**KIRKLEES METROPOLITAN COUNCIL
INVESTMENT & REGENERATION SERVICE**

Reference No: 2021/60/92462/W

Site Address: rear of, 1091, Manchester Road, Linthwaite,
Huddersfield, HD7 5LS

Description: Outline application for erection of detached dwelling

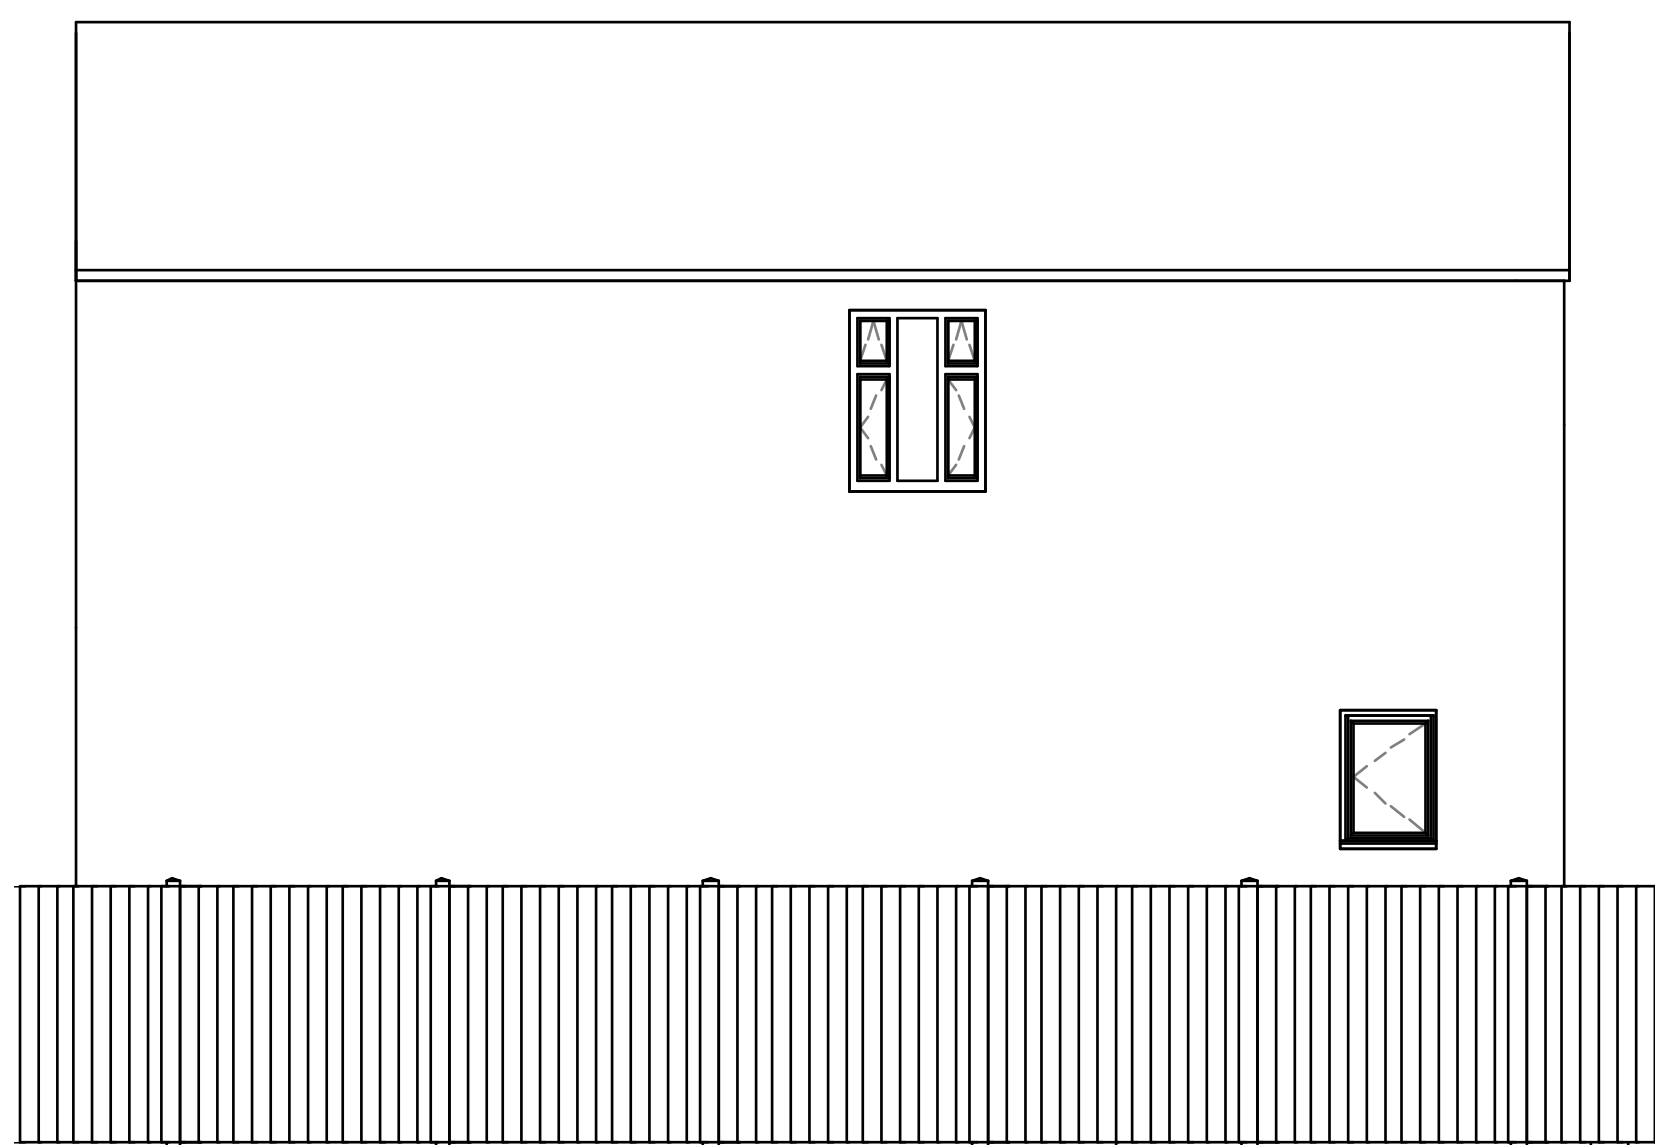
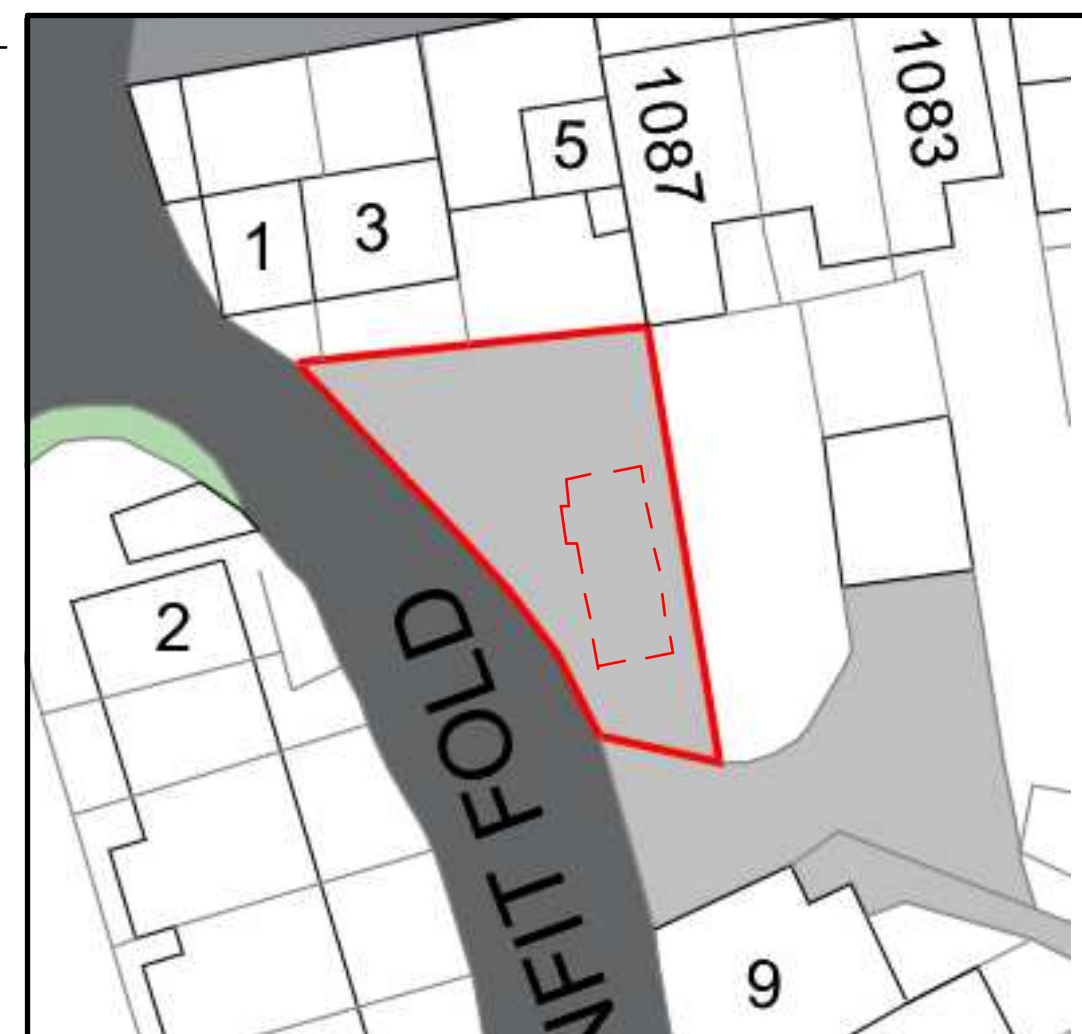
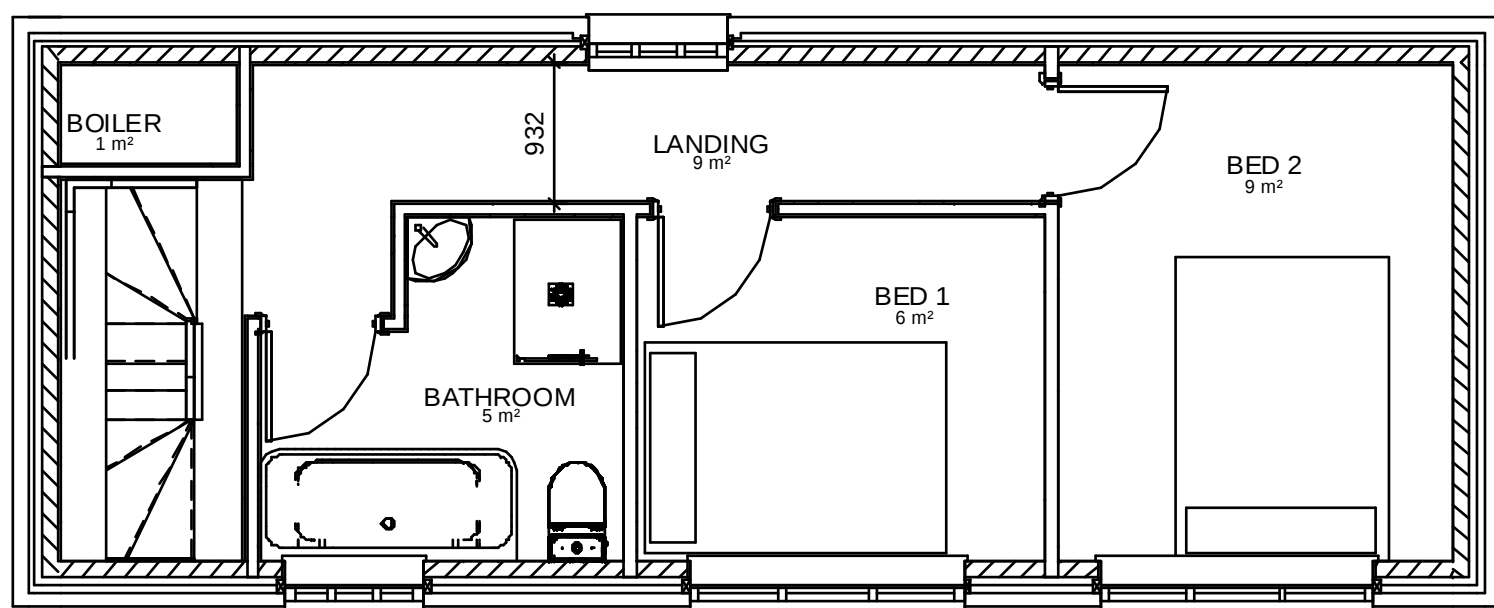
The application site is considered to be small for a dwelling at 195 square metres, with its triangular shape further restricting the potential for the suitable development of the site. It has been noted that the indicative layout now proposes a smaller dwelling, with only two bedrooms and one off street parking space. The dwelling is to be placed towards the southern end of the

site but would still be situated 0.3m from the boundary edge. More specifically the internal floor space has been measured at 64 sq. m, which is a slight reduction from the previous scheme, however, this raises concerns from an amenity perspective. Therefore, whilst layout has not been applied for, the indicative details are considered likely and these highlight that the erection of a dwelling on the site would appear cramped and would provide a poor level of amenity for its future occupants.

As such, it has still been considered that the proposed development would have a significant overbearing and oppressive impact upon these neighbours amenity, along with their outdoor amenity space. This is due to the sloping nature of the site, which would result in any potential development being on a greater level than these neighbours. With regards to the indicative plans, these show a two storey dwelling to be proposed, which would be within 10m from the nearest elevation at no. 3 and 14m from no. 5.

Whilst officers acknowledge that the plans submitted as part of this proposal are indicative, they provide a reasonable demonstration to the level of internal floor space likely to be achieved. In this case, the development proposes a two storey, two bedroom dwelling in which would have an internal floor space, significantly below the governments technical housing standards at 64 sq. m. This would be 15 sq. m below the national guidance and would be contrary to paragraph 9.1 of the Council's Housebuilders Design Guide SPD. This therefore demonstrates that an appropriate level of amenity cannot be created, in a way that does not result in the overdevelopment of the site.

1. The proposed residential development, in relation to plot size and taking into account its relationship with surrounding development, would represent a cramped form of development constituting an overdevelopment of the site. It would fail to add to the overall quality of the area or result in a scheme that is visually attractive. Furthermore, the proposal, would fail to preserve or enhance the setting of the neighbouring listed buildings, by occupying a substantial part of the existing open space, which is currently used to contrast with the built form and to provide views of the listed buildings, particularly those to the North. The development would therefore cause harm to the significance of the designated heritage assets and to the wider visual amenity of the area. No public benefits have been put forward to outweigh the identified harm to the setting of the listed buildings. The development would therefore be contrary to the Council's duties under the Planning (Listed Buildings and Conservation Areas) Act 1990, policies LP24a and LP35 of the Kirklees Local Plan, Principle 2 and paragraph 6.12 of the Council's Housebuilders Design Guide SPD and Chapters 12 and 16 of the National Planning Policy Framework.

2. The proposed residential development, when taking into account the changes in topography in the surrounding area and the close proximity between the application site and the principal elevations of 1, 2, 3, 5, 7 and 9 Linfit Fold, would have a significant overbearing and oppressive impact upon these neighbours amenity and outlook and could potentially lead to detrimental overlooking. This would not provide a high standard of amenity for neighbouring occupiers, contrary to Policy LP24(b) of the Kirklees Local Plan, Principle 6 of the Council's Housebuilders Design Guide and paragraph 127(f) of the National Planning Policy Framework.
